Application No: FP/136/21/PL
Site Address: Beachcroft Hotel Clyde Road Felpham PO22 7AH
Description of works: Re-modelling of existing swimming pool with re-clad elevations and private roof terrace over. This site is in CIL Zone 4 (Zero Rated) as other development.

Thank you for your internet representation made on 14th July 2021 which has been recorded as an objection with the comments as follows:

Proposed Roof Terrace Plan

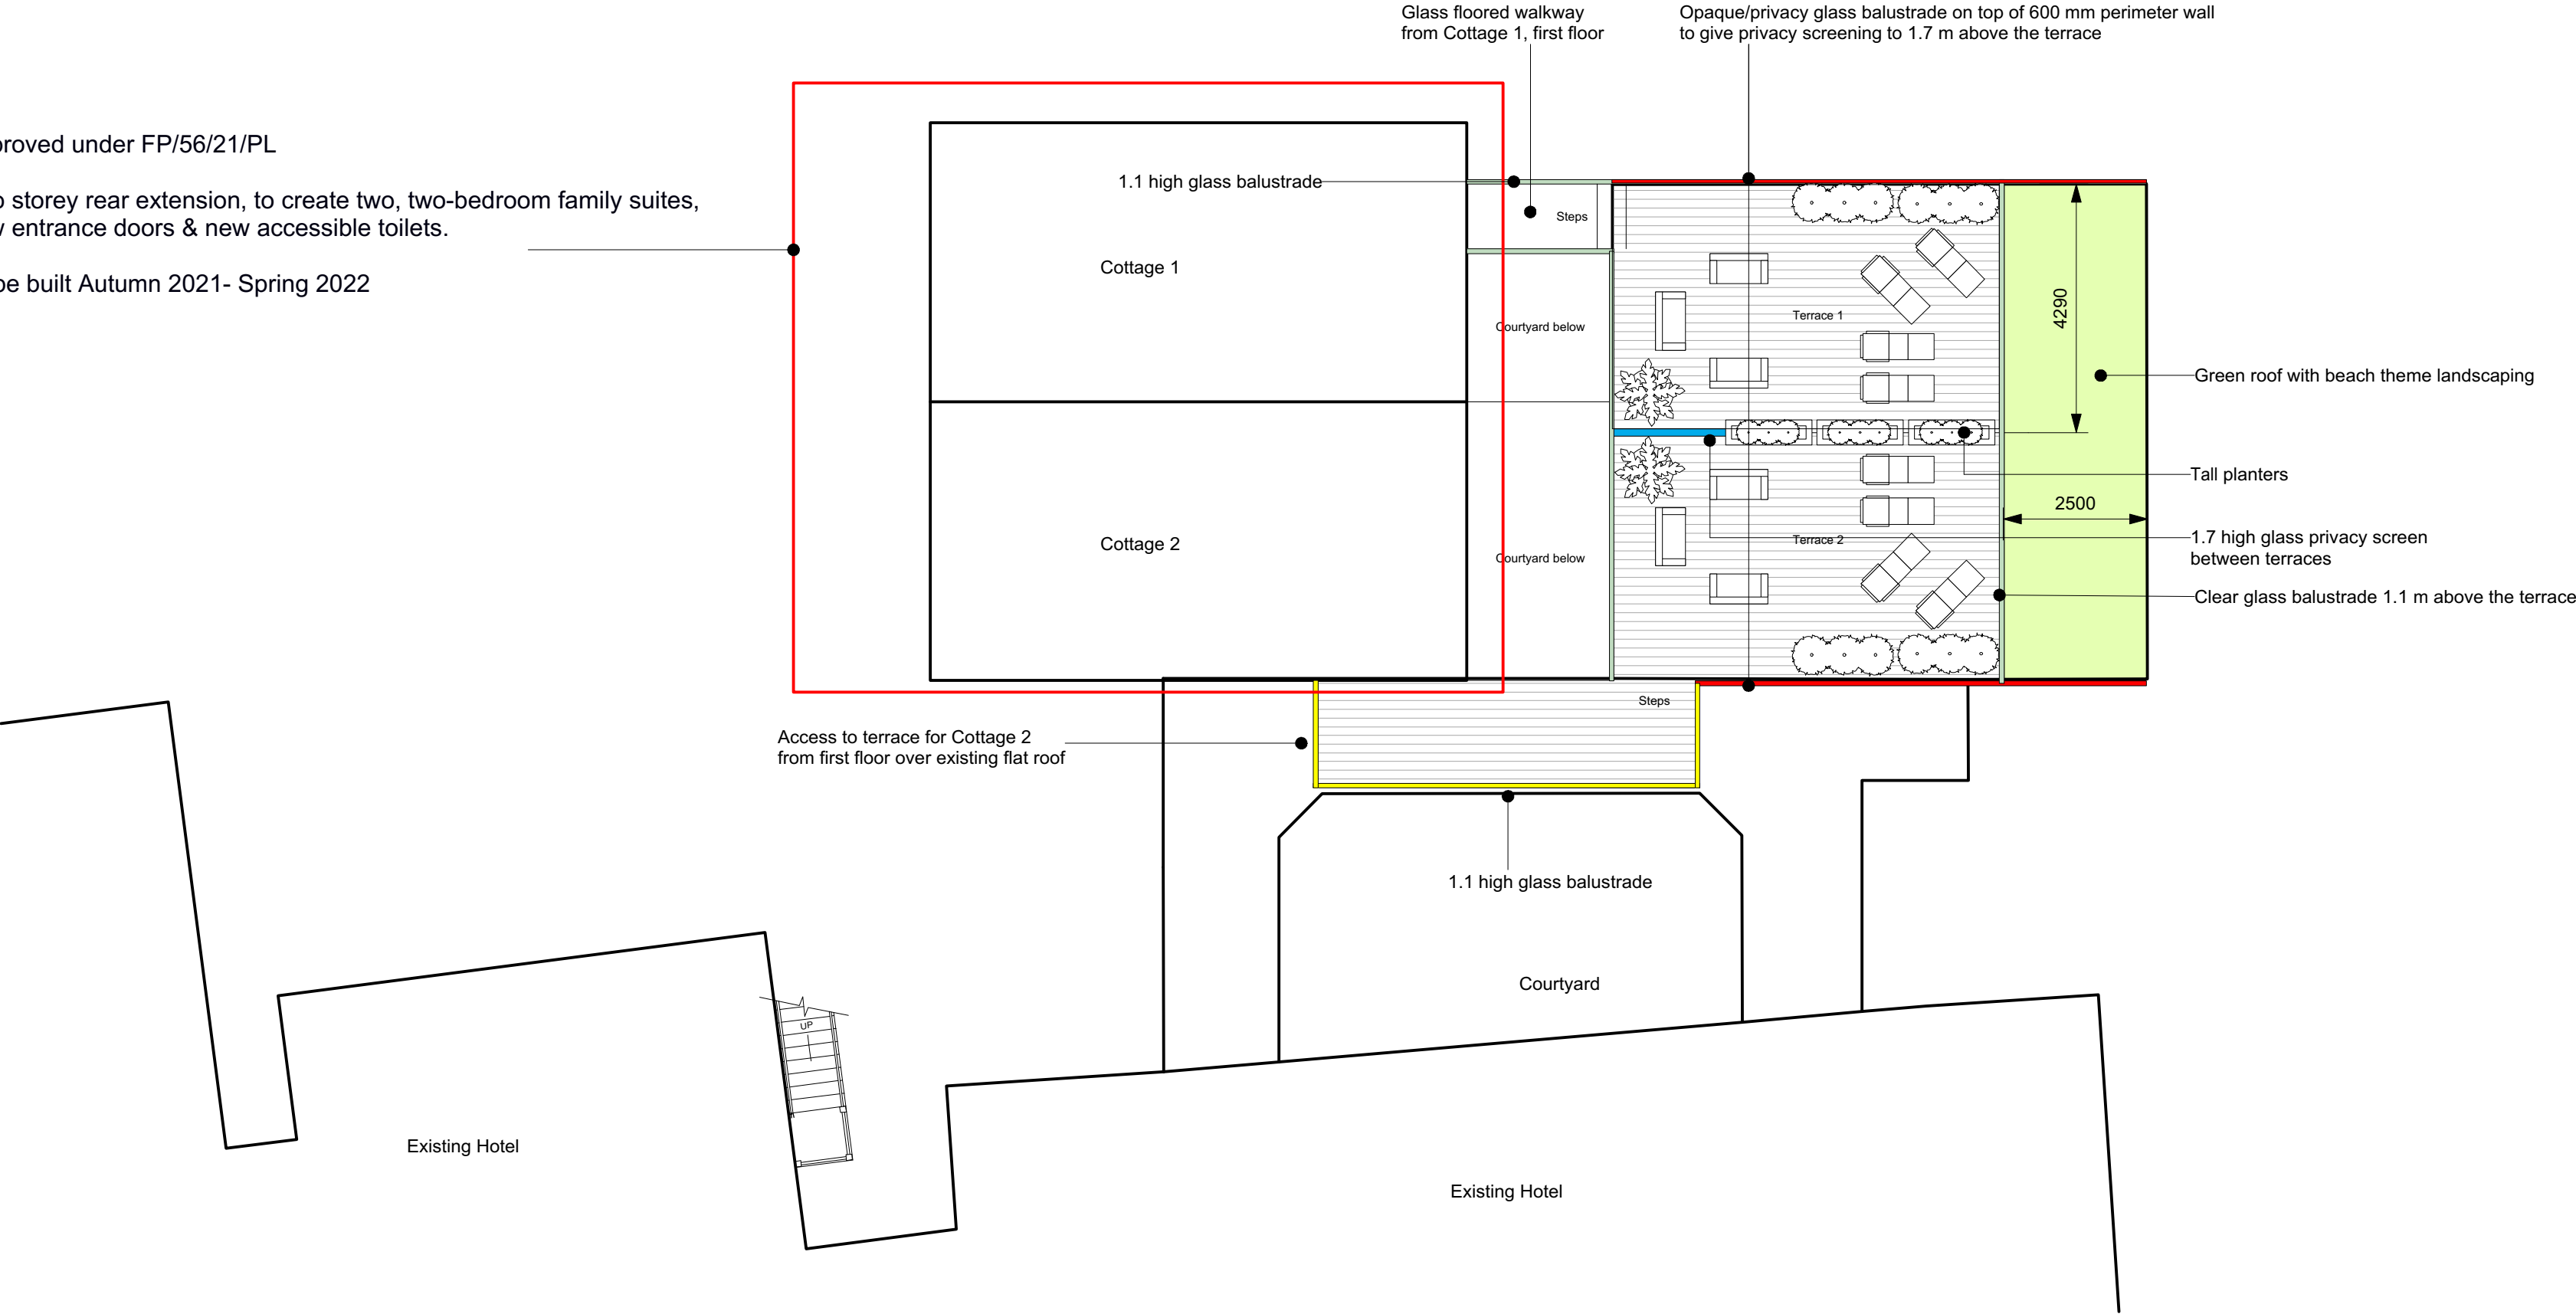
The proposed construction of the roof terrace above the hotel swimming pool building and the walkway from the planned new extended accommodation block will undoubtedly give the hotel guests a direct view into our flat, which is on the first floor of Canning Court directly across the road and on approximately the same level as the proposed terrace. This also raises the issue of potential noise pollution.

We request that the permission for this development project be granted only on condition that the glass barriers on the terrace and the walkway facing our flats be replaced with non-transparent soundproof covering.
